Our Ref: R/114/19/HH
Your Ref:

Town & Country Planning Act 1990 (as amended)
Town & Country Planning (Development Management Procedure) (England) Order 2015
Application for Planning Permission for Works or Extension to a Dwelling

Development Proposed side porch
Location 2 Amberley Road Rustington

Site plan 1:500

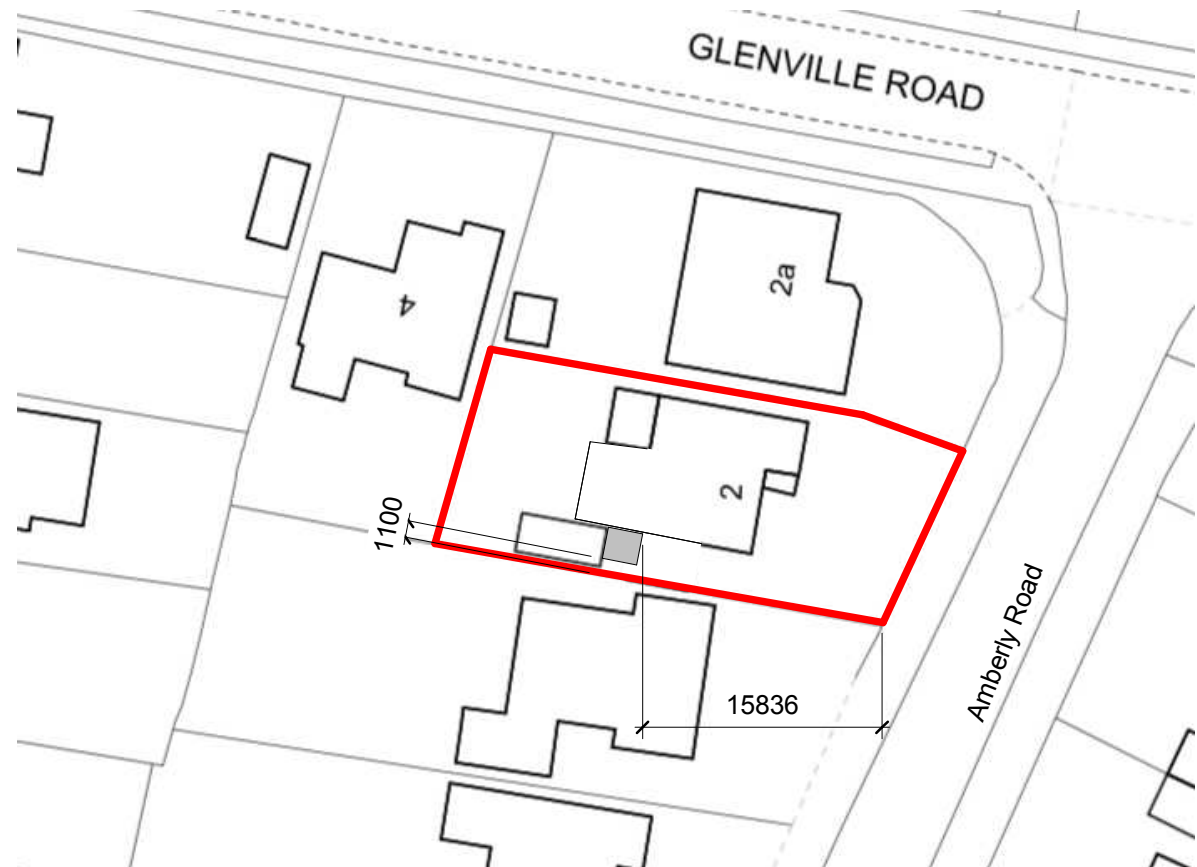
Block Plan

Please submit 1 electronic or 3 paper copies of a block/site plan which includes dimensions from the proposed side extension to all site boundaries.
